Director City Planning Report No. CP70/16

Subject: CBD and South East Light Rail -
proposed modification to permit
tree works

Folder No: F2014/00453

Figure 1 – Location of the two mature trees on the corner of Alison and Darley Road shown in red.

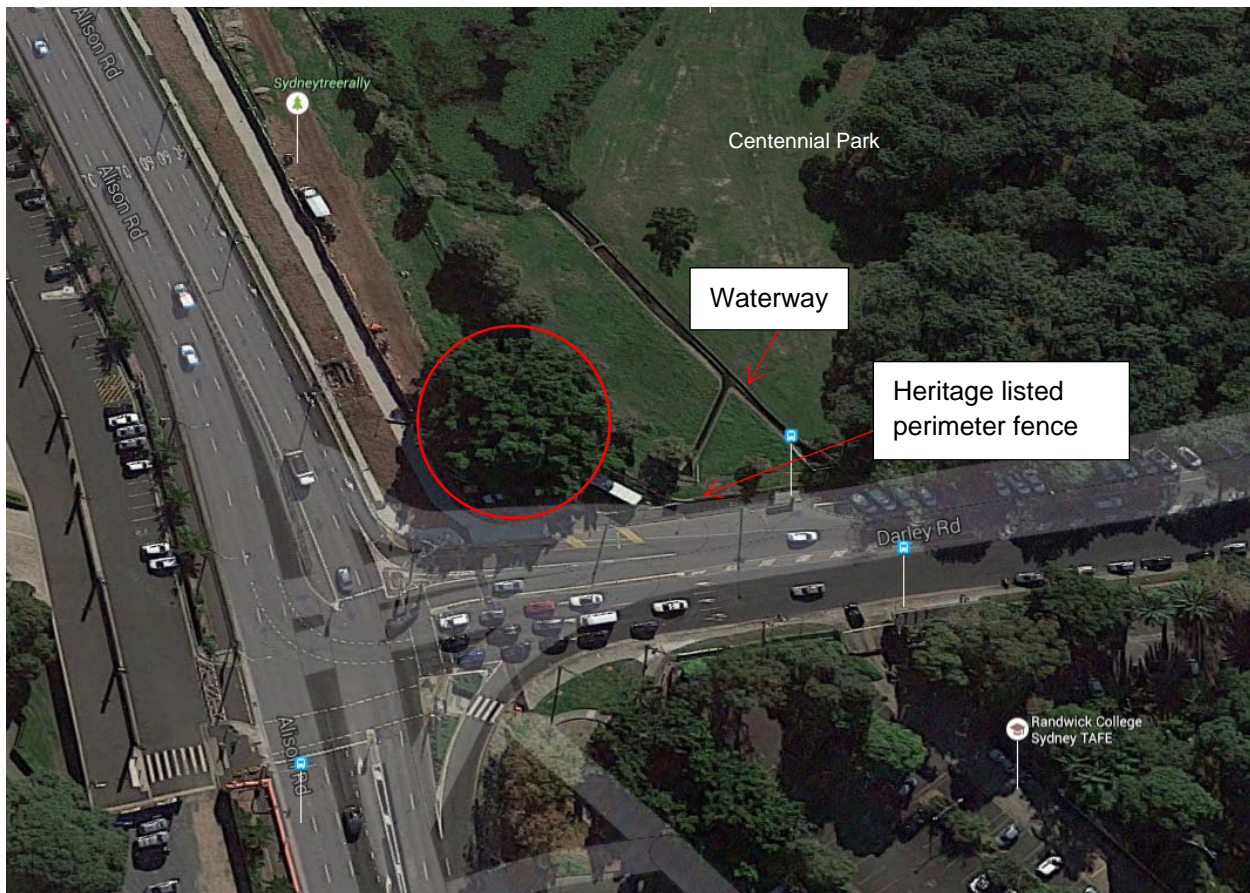
The Modification notes that the proposed tree works would require the removal of less than 10% of the crown from each tree. Minor pruning would be required in future, to maintain the clearance around the overhead wires of the light rail line. It is noted that the 3 metre clearance as stated in the report is incorrect; 2.7 metre clearance has been previously adopted for Alison Road.

Council's Tree Management Coordinator has assessed the proposal to remove less than 10% of the crown canopy from each tree and advises that there should be no

adverse impacts that will affect the health and vigour of the trees. It is noted that Council's tree preservation policy for trees in the Randwick LGA allow for 10% of tree canopy to be removed without a Council consent.

Most importantly to the health of the trees is adherence to the appropriate root pruning practices in accordance with the Australian Standards, as stated in the Modification Report. Council advises that prior to any root pruning works, a hand dug trench 1.5m deep by 200mm wide be excavated along the southern side of the structural root zone (Alison Rd side) for an independent arborist to further assess impacts to tree roots.

The key concern with this proposed Modification is that it provides insufficient protection of the trees from impact beyond the 10% currently anticipated. The proposed changed wording of the Conditions of Approval does not limit the extent of tree work allowed to the trees, and creates conditions in which additional and potentially substantial tree work, or even removal, could occur without further formal approval requirements.

1. Council endorses making a submission to the Department of Planning and Environment objecting to the Proposed Modification, and;
2. Council recommends that the proposed modification be re-evaluated on the basis of a 2.7 metre clearance around the overhead wires for the light rail.
